## City of CS-Tutt Road & Cottonwood Drainage Project

March 3<sup>rd</sup>, 2019

Please find attached response to first round of staff comments. Also included in the resubmittal is a new subdivision exemption plat exhibit for your consideration:

SHEET 1 OF 2

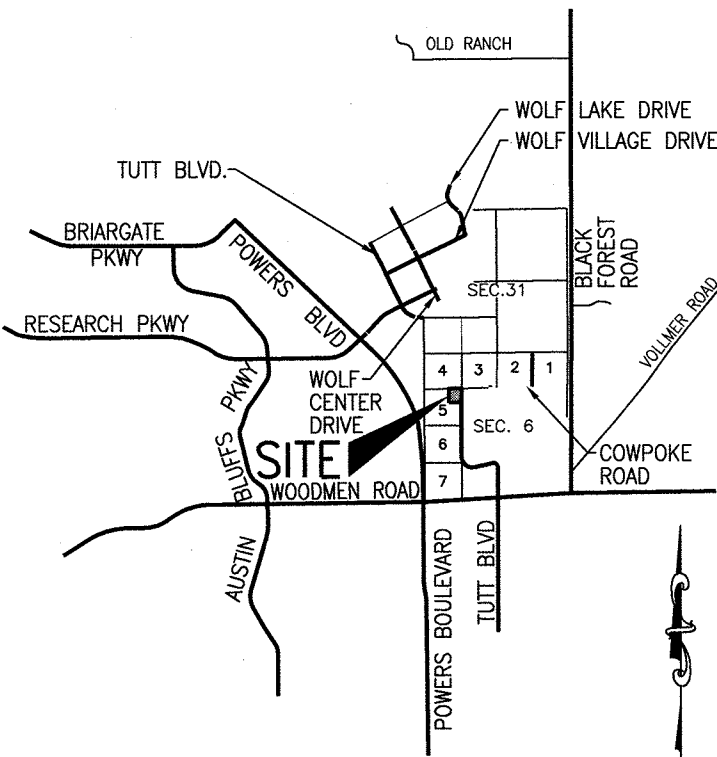
Floodplain has the following comments:

The new parcel intended to contain the detention pond contains FEMA identified Zone AE floodway. A CLOMR and LOMR must be approved by FEMA before any work can begin on the detention pond. Contact Floodplain Administrator Keith Curtis (keith@pprbd.org, 719-327-2898) with any questions or concerns regarding compliance the FEMA regulations and Regional Building Code. 2. The area of proposed Tract A which contains floodplain area must be designated as a “no build” and “no storage of materials” area on the plat.

See attached (revised) subdivision exemption plat map indicating “no build” and “no storage of materials” in note 10 on sheet 1 of the plat.

SHEET 2 OF 2

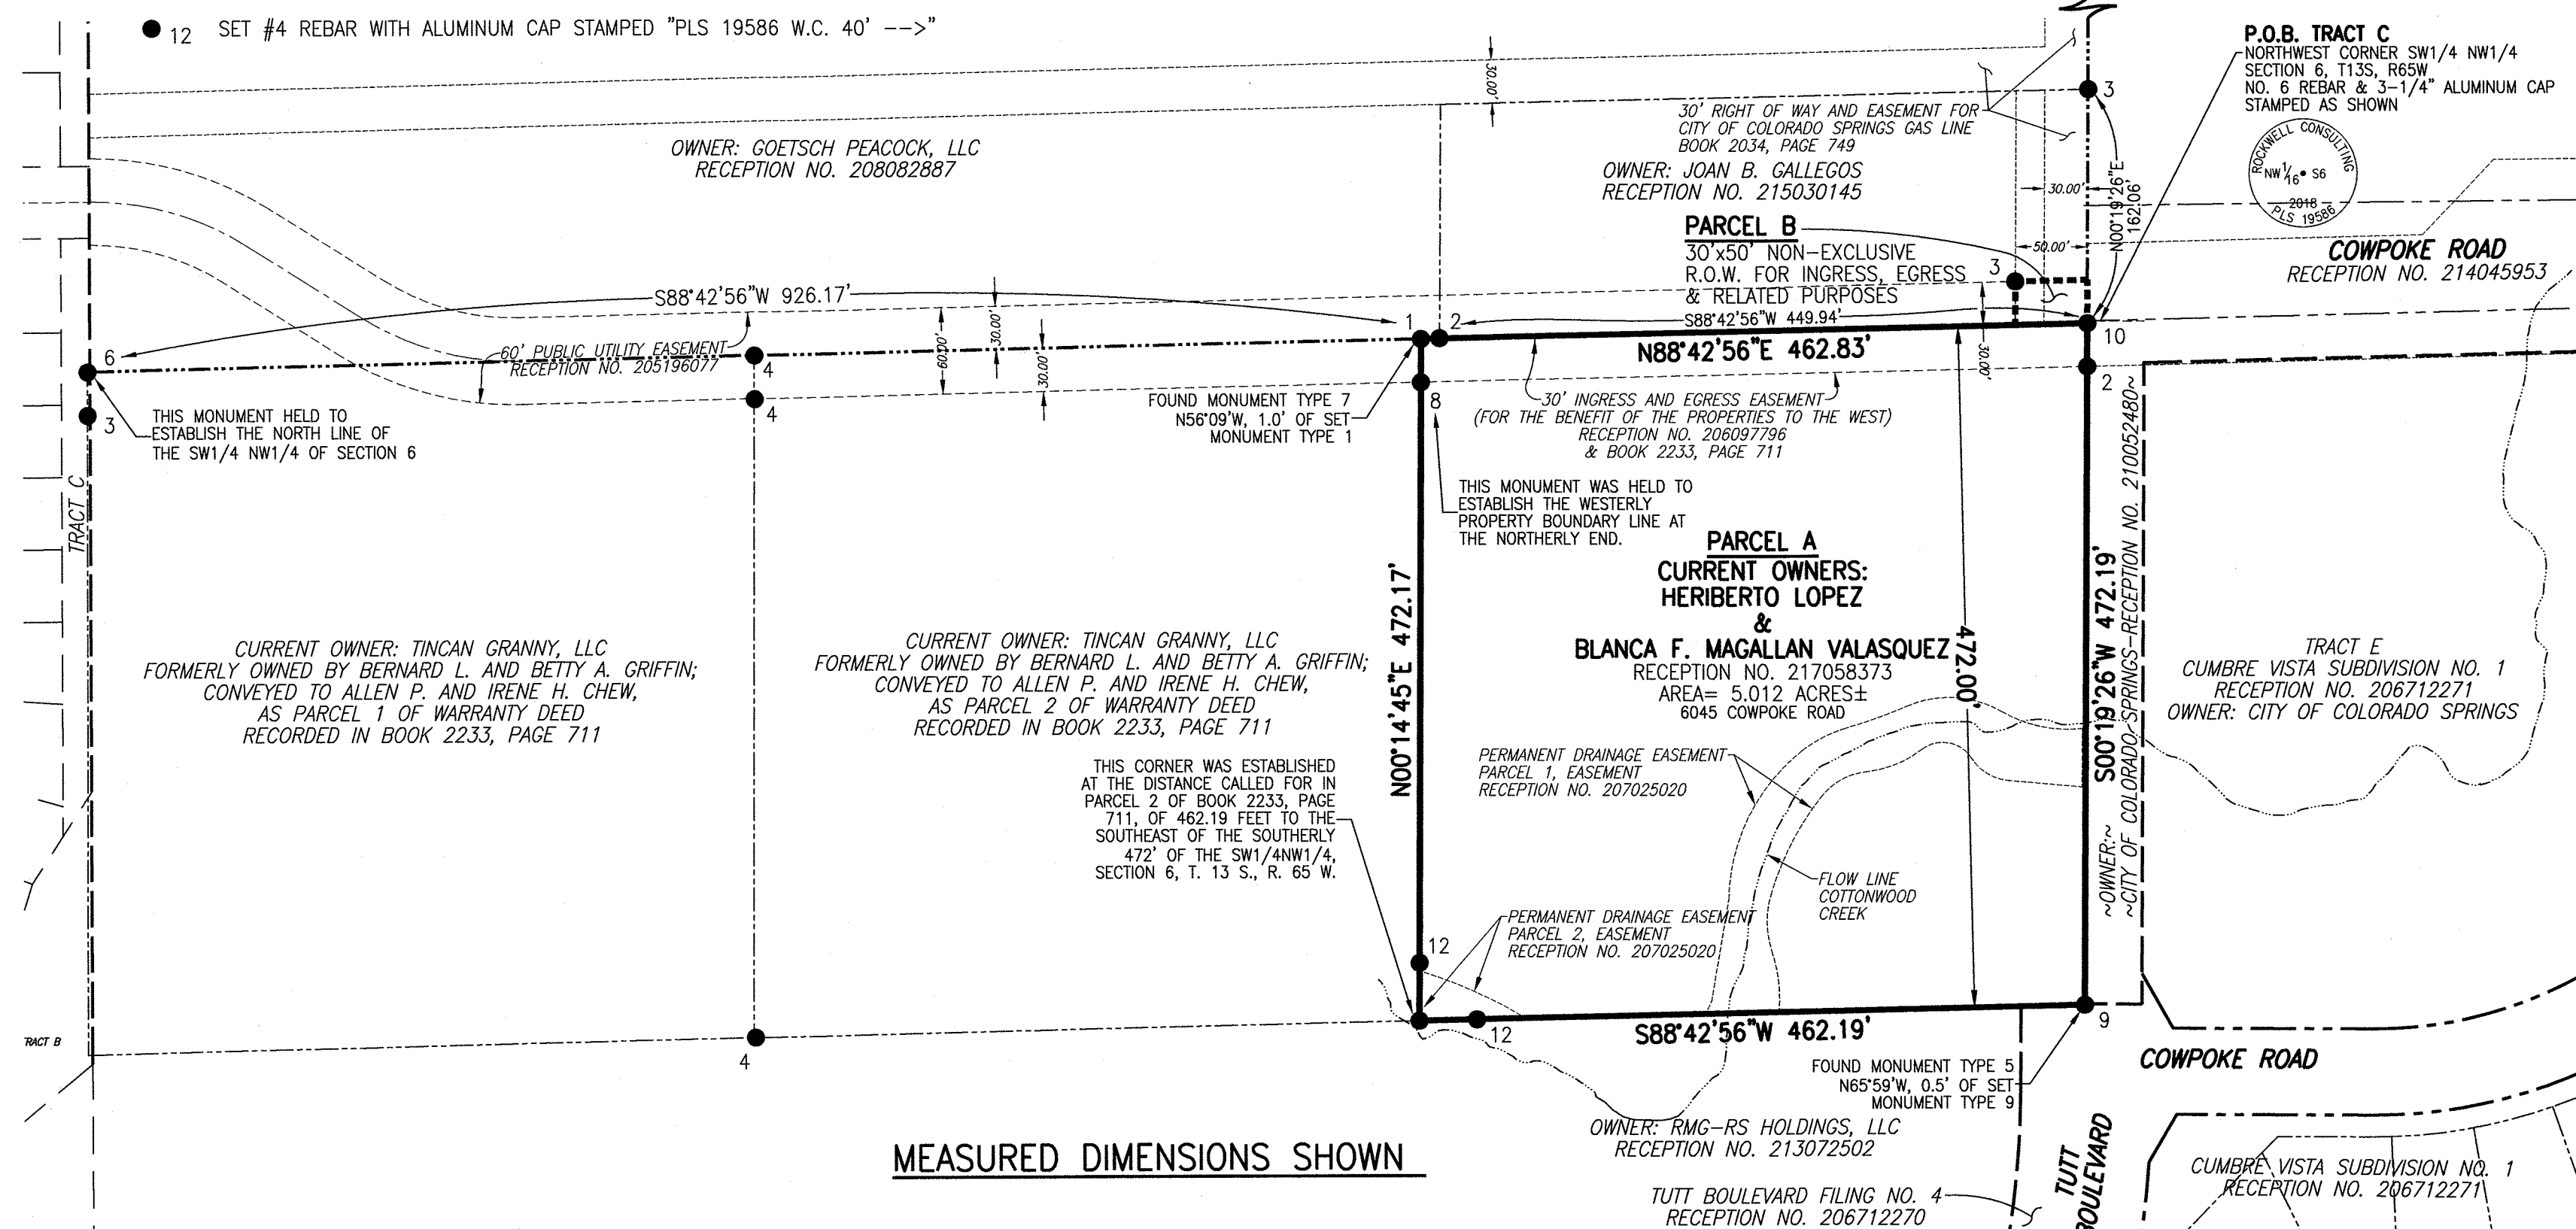
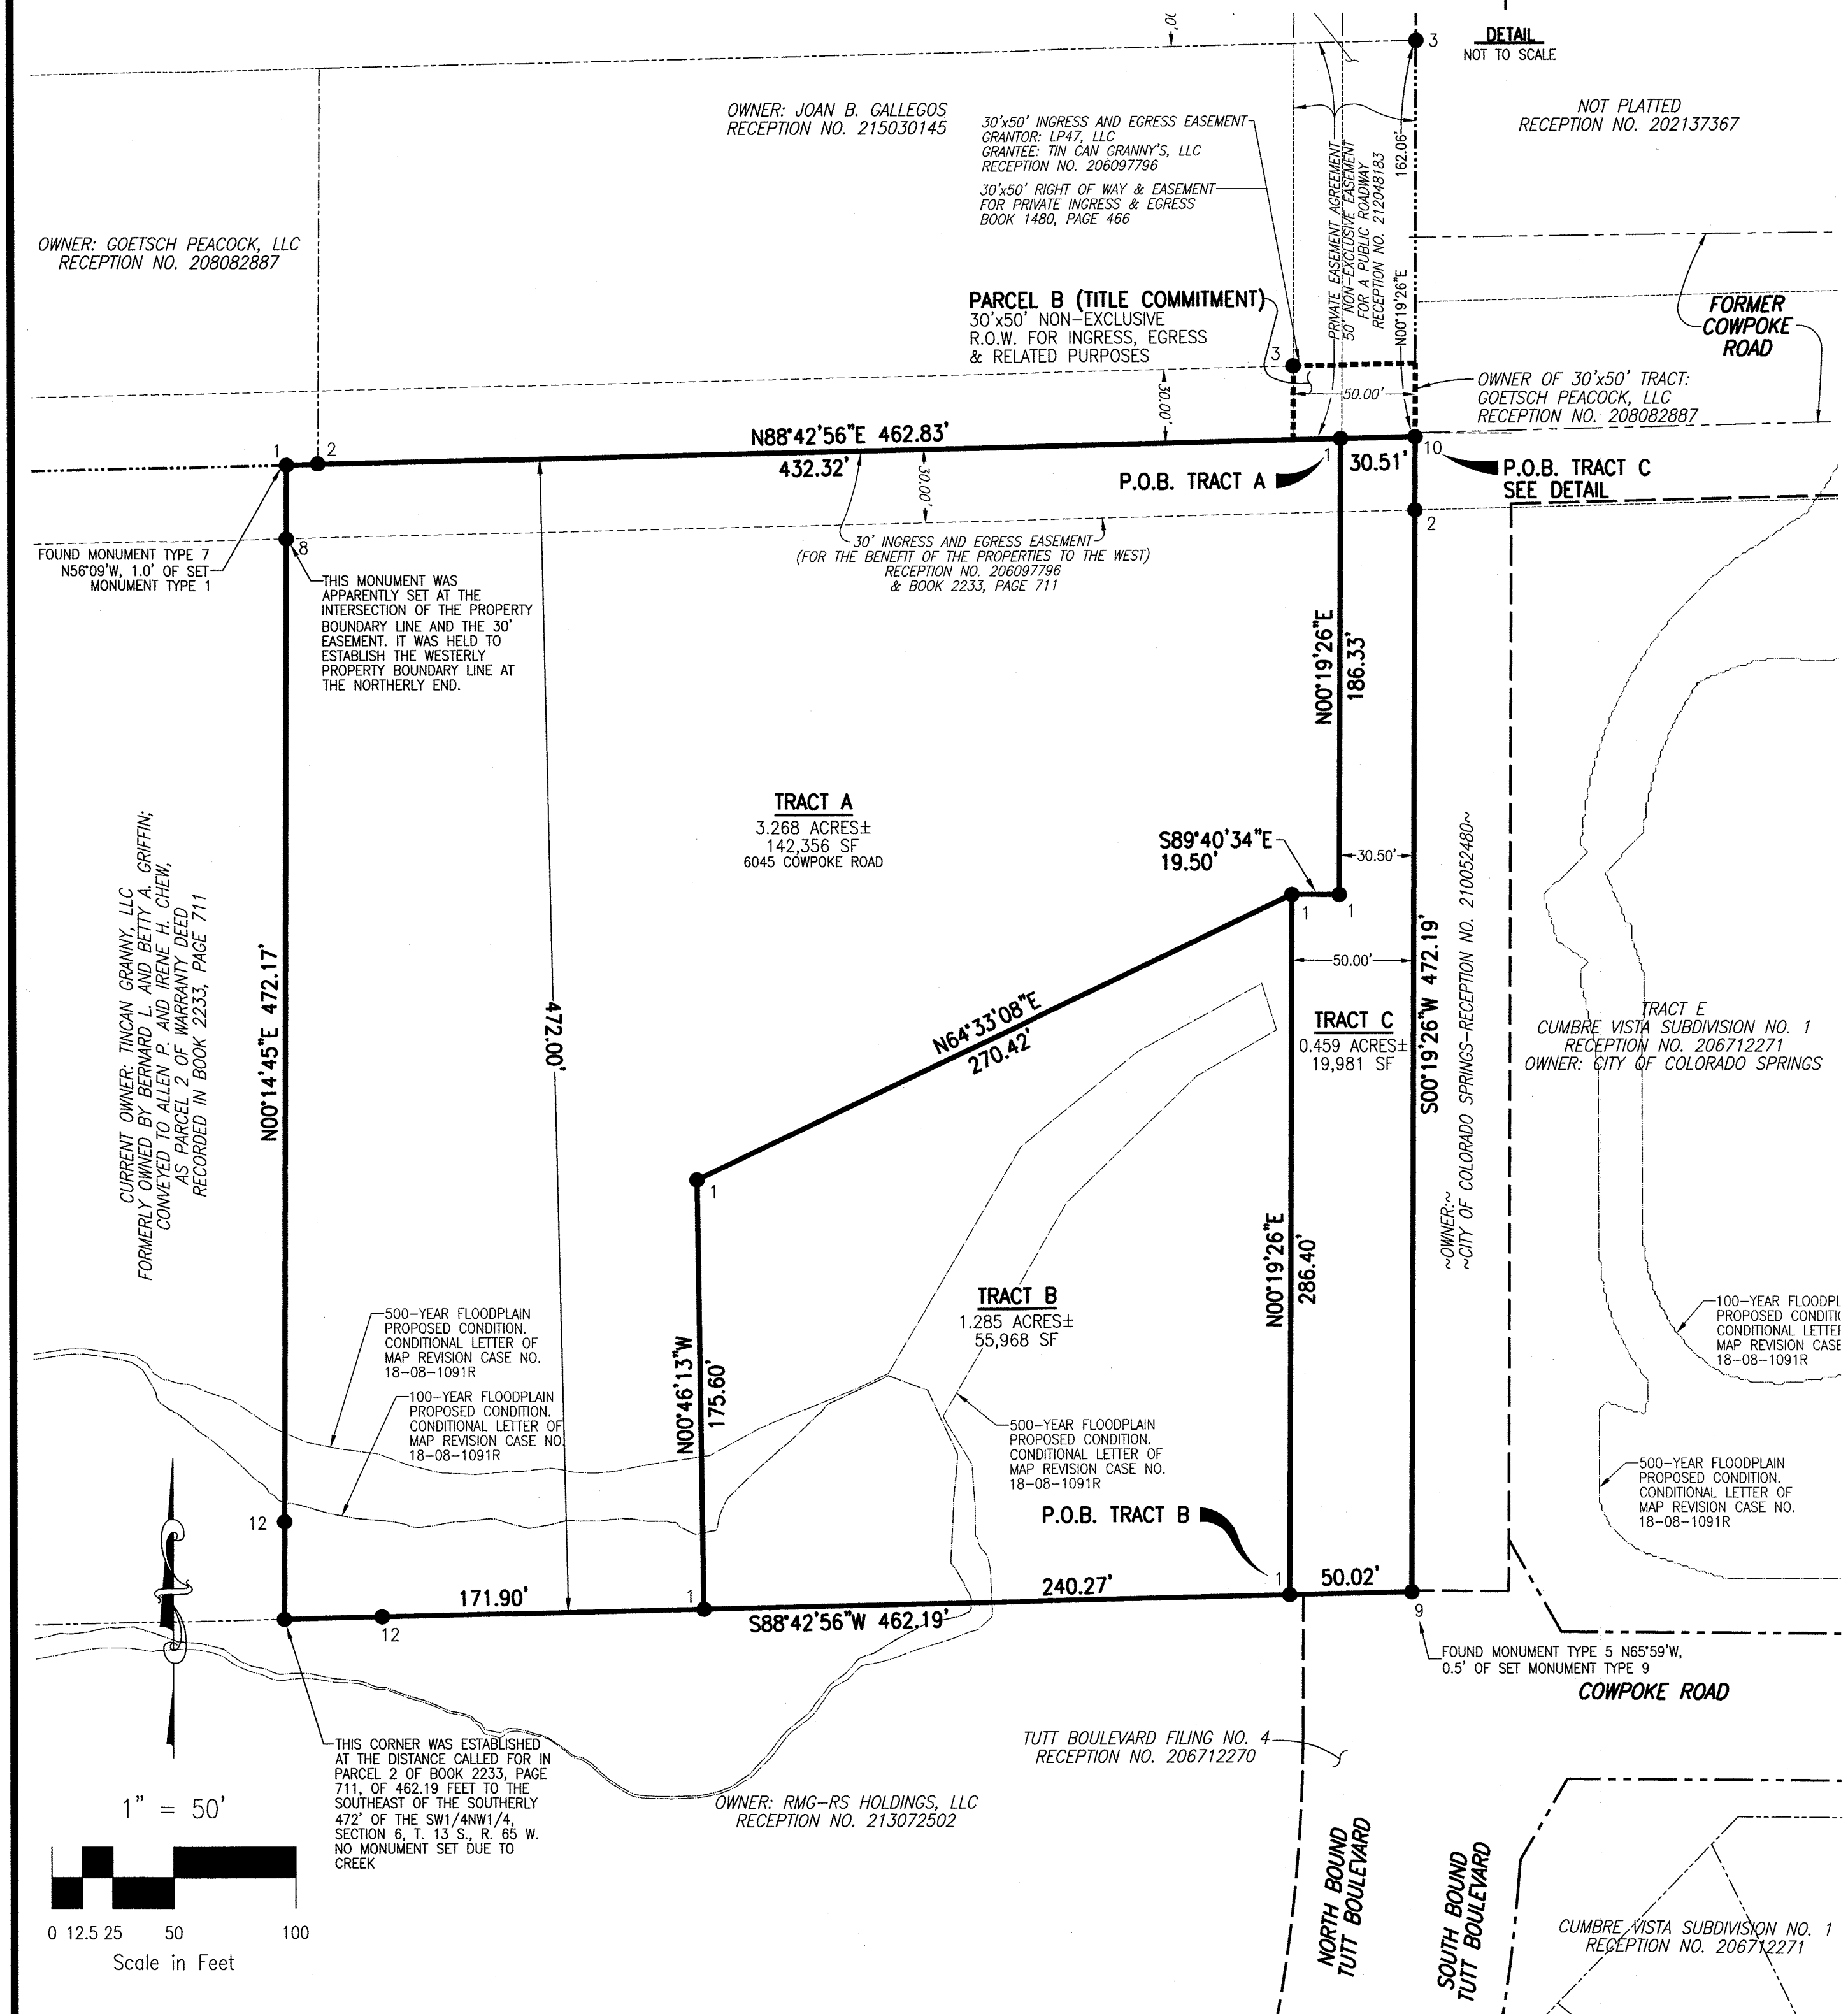
Comments on Exemption Plat V1 by Gabe Sevigny:

Text in green boxes was added to plat.

We have tried to clean up the plat as much as possible but cannot remove some of the lot information to the west (top left corner of sheet 2). Those parcels were created based on a document that initially refers to all 3 lots and then all subsequent ownership changes referred back to the parent document. Unfortunately, this chain of survey information needs to be shown on the subdivision exemption plat for the licensed surveyor (John Bailey, PLS) to stamp the plan.
